From: Ellie Myers
Sent: Wednesday, October 8, 2025 12:55 PM
To: 'Josh Pozzobon'; Ian Garrity
Cc: Jamey Ayling
Subject: RE: Built - Septic Layout and Site Plan for 1151 Wapiti Dr
Attachments: VA-25-00006 Schwartz - Correspondence - Deemed Complete.pdf

I spoke with my planning manager, and we have enough information to move forward with notice of application for this variance and the shoreline exemption since it sounds like the site plan will work. So, we can get started on this while Mark works out the details with Dan.

# SITE PLAN - NEW SEPTIC

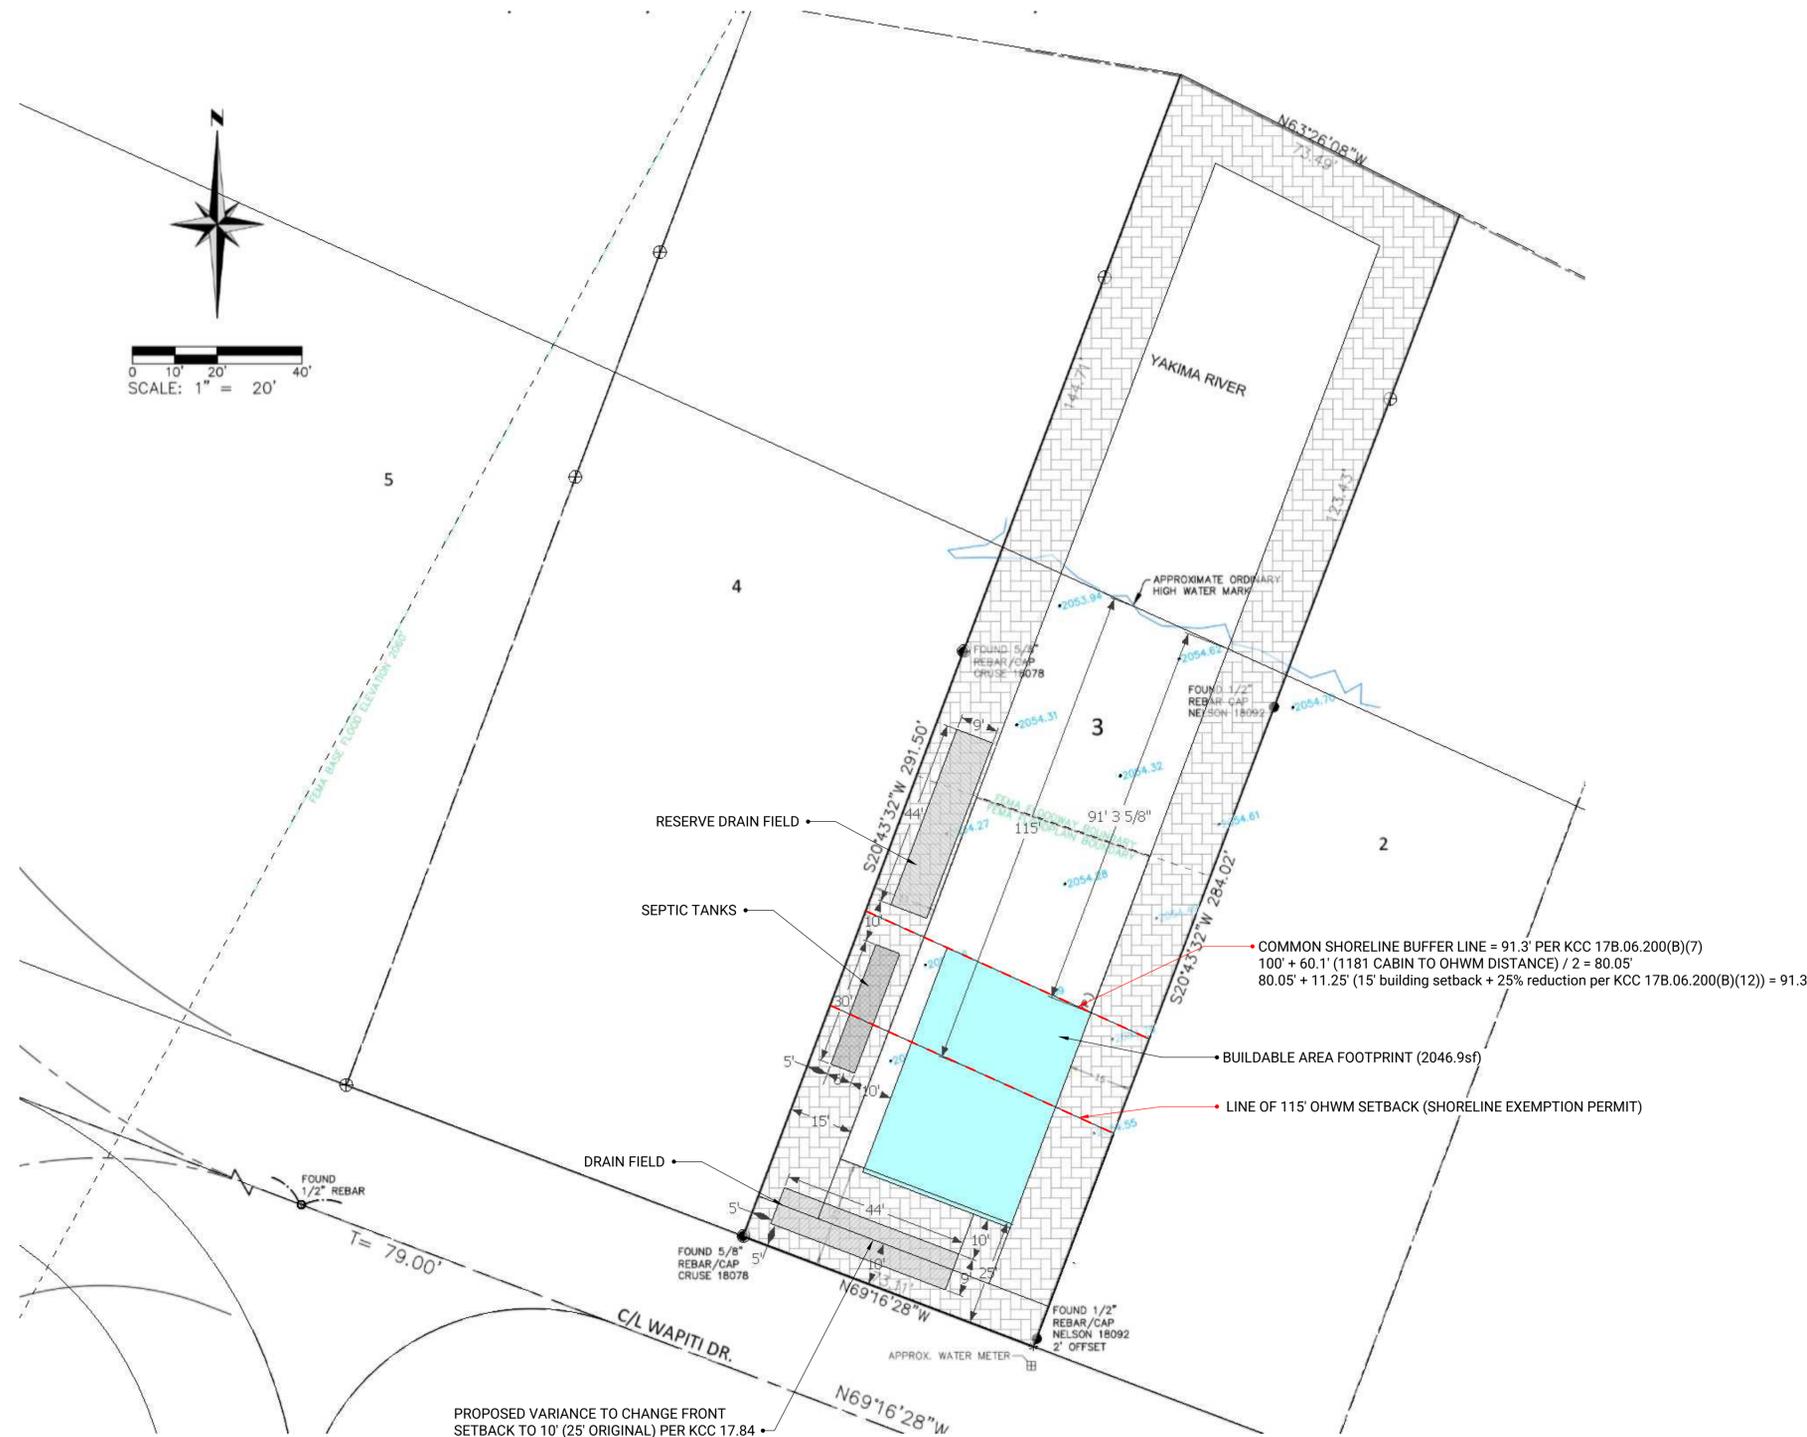
Ellie - Here is the updated Site Plan. Confirm we have added the septic setbacks from the property line (5'), setbacks to the buildable area from septic (10'), etc. The approved shoreline buffer is also in here, Ellie.

Dan - Attached is the updated Site Plan. Please confirm the septic looks okay to you and we can progress.
